# Department for Transport

**Application by National Highways Limited ("the Applicant") for an Order granting Development Consent** for the provision of the proposed A47 Blofield to North Burlingham Project ("the Proposed Development") to provide additional road capacity through the de-trunking of an existing single lane section of the A47 between Blofield and North Burlingham, and its replacement with a new section of dual carriageway to tie in with the existing A47.

### **REQUEST FOR COMMENTS FROM THE APPLICANT AND NORFOLK COUNTY COUNCIL ("NCC")**

### **Land Plans**

Location

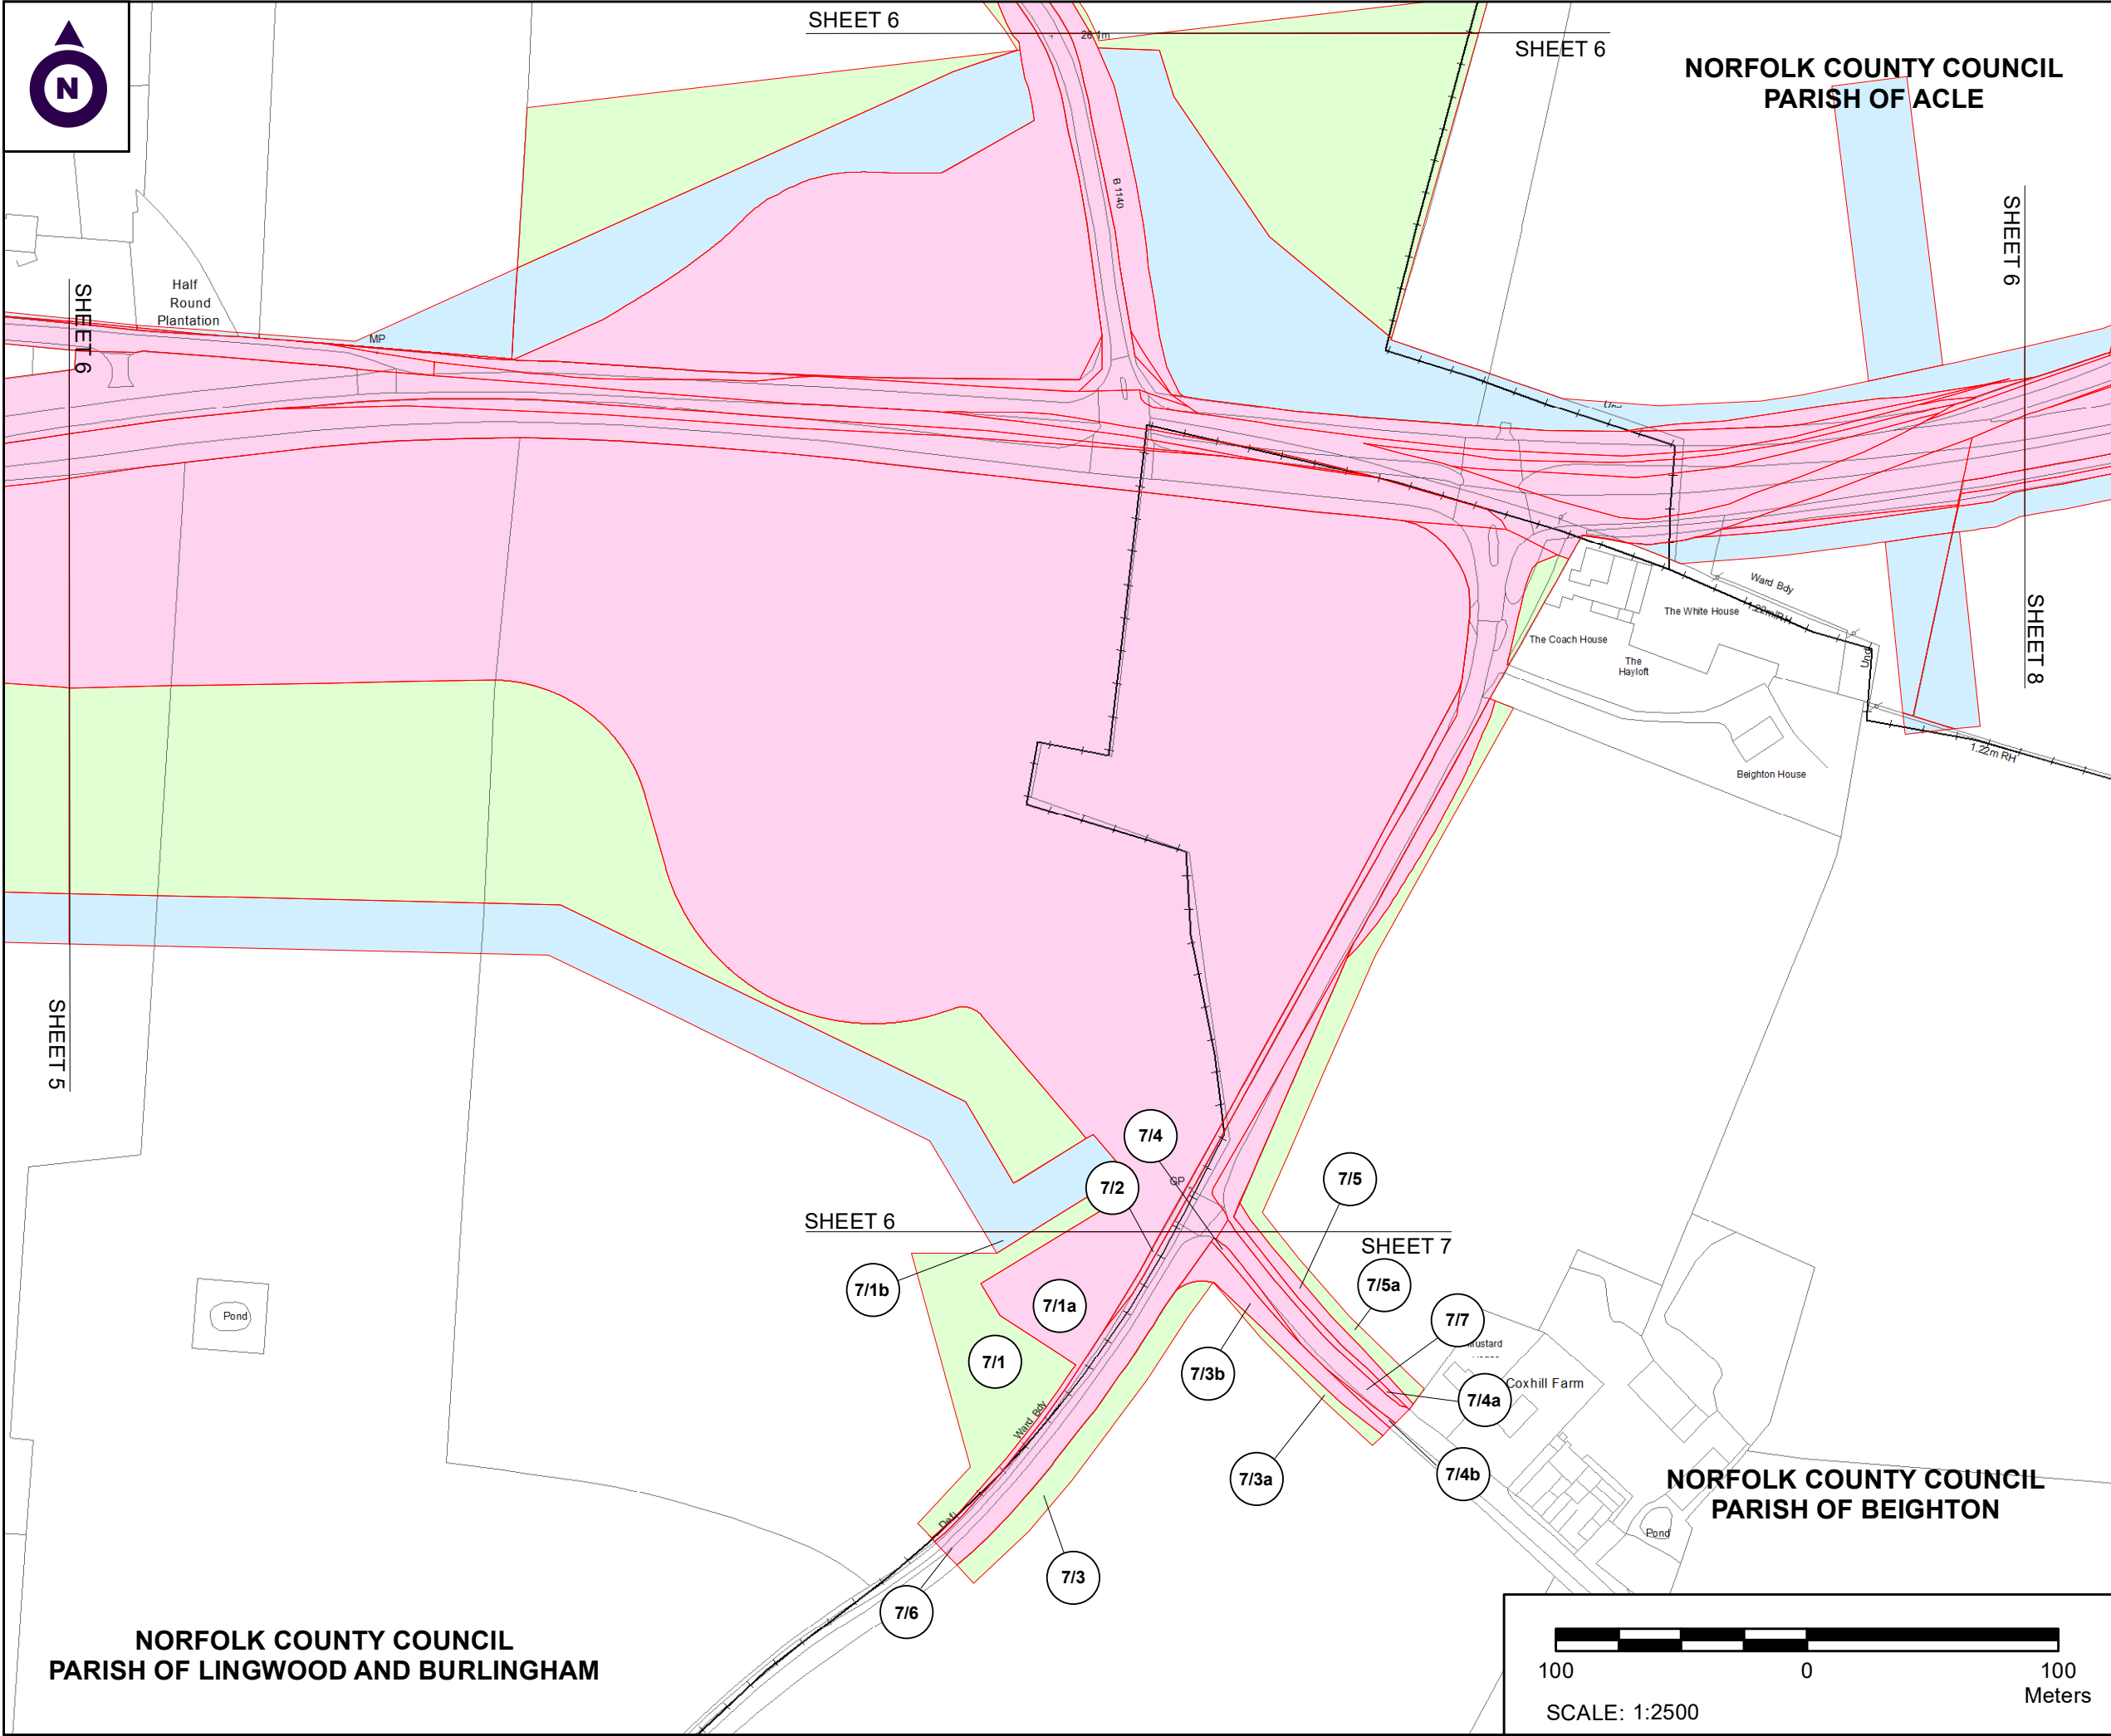
Please could the **Applicant** provide an amended version of the Land Plans. Plot 4/7c is annotated on Inset G on Sheet 4 of the Land Plans [\[REP4-002\]](#). This is an error (as Plot 4/7c is correctly shown elsewhere on Sheet 4) which the Inspector requested the Applicant correct. Whilst the Applicant indicated it had done so (Ref 3.2 on page 33 of [\[REP4-051\]](#)), this does not appear to be the case.
